North Wambo Underground Coal Mine MOD 14 (LW 10a) – additional information

**NSW Office of Water's detailed technical advice:
North Wambo Coal Mine MOD 14 – additional information**

Figure 1. Ramp functions applied in the Wambo regional groundwater model

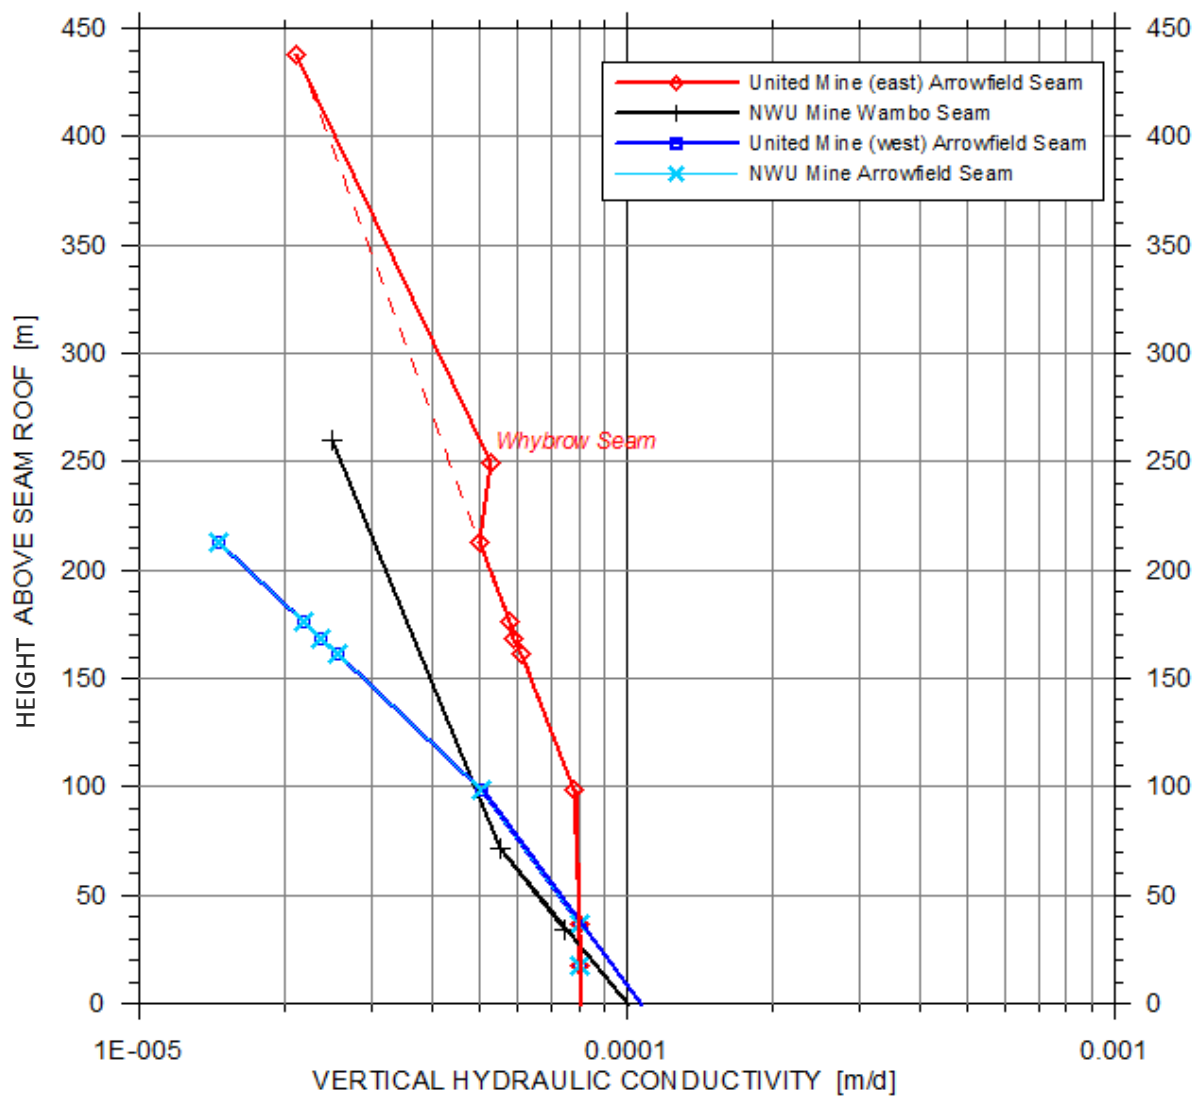
The Kz max values applied in the model are constrained to very low values as not to be consistent with the textural description of the A fracture zone. Whilst it is acknowledged that model calibration was achieved applying such low values in this instance, other groundwater models can also achieve calibration applying log linear decay in Kz without the need to overly constrain the starting values. A recent example for Southern Coalfields is Russell Vale Colliery where similarly to WCPL they applied a Kz value of 10 for the mined out coal seam but follow a more consistent decay function for the overlying layers (see Table below). The Kz for the interburden layer immediately overlying a mined seam is 1 m/day for Russel Vale, whereas WCPL constrains this to a value some 10000 times less. The limiting Kz value applied by WCPL under this multi-coal seam proposal where significant fracturing has already been historically observed, is under estimating the vertical connectivity and consequential impacts between the alluvium and Permian groundwater systems.

Figure 3. Recovery hydrographs at synthetic monitoring bore LW10A

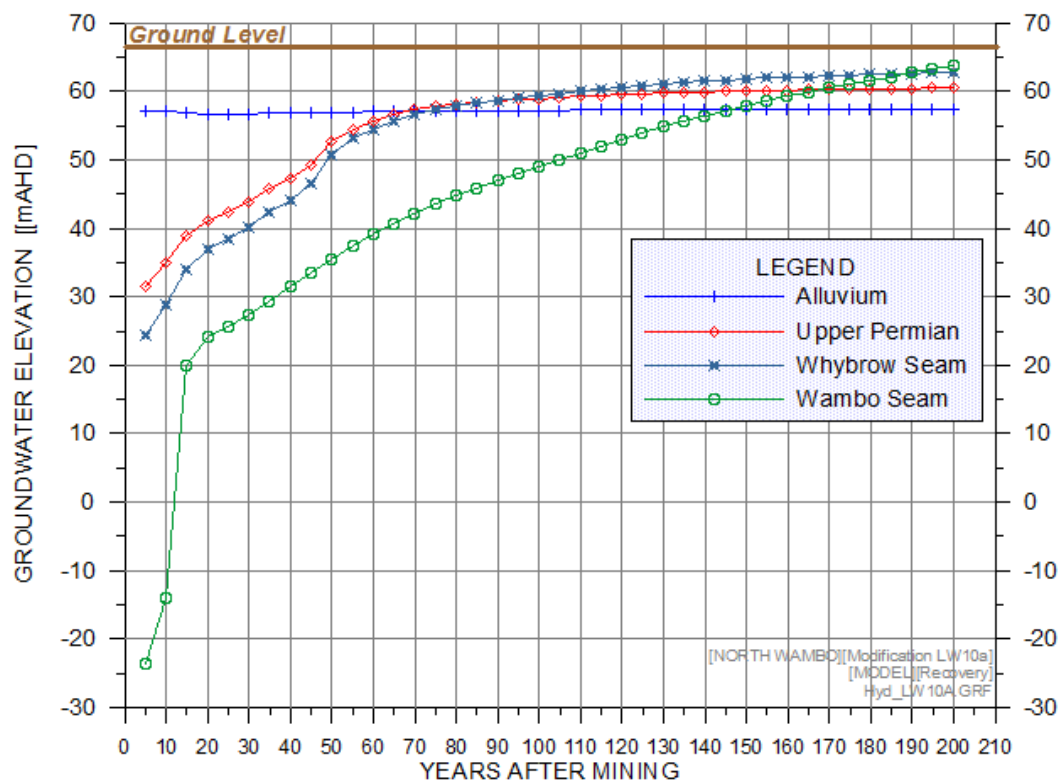
WCPL present in Figure 1 below the hydrograph modelling results for a synthetic bore located in the midpoint of LW10A. Figure 1 presents a 3m (upflow) head difference is generated between Permian and alluvium. Whilst the proponent does now acknowledge the upflow, it remains that the groundwater model doesn't incorporate the substantial land subsidence that will occur in this location. Observation point P114 is an actual alluvial bore located in mid-point of LW10A and had pre-mining levels around 58m AHD (Figure 2), i.e. identical to that of the synthetic bore. Previous Office of Water commentary has demonstrated the alluvium in LW10A will be subsided by as much as 9.5m in this area.

The proponent continues to side step subsidence as an issue for groundwater flux. Given the groundwater model can not assess what can logically be concluded, concerns with the long term impacts of the proposal remain. By ignoring this issue the proponent has not demonstrated with sufficient rigour the impacts of the proposal. It is clear that the upflow from the Permian to the alluvium is predicted which results in the mixing of aquifers of different water quality. Under increased Kz being generated in the Permian combined with alluvial land subsidence, these impacts will be greater than that put forward in the supplementary report. Further, this outcome contradicts that presented in the EA.
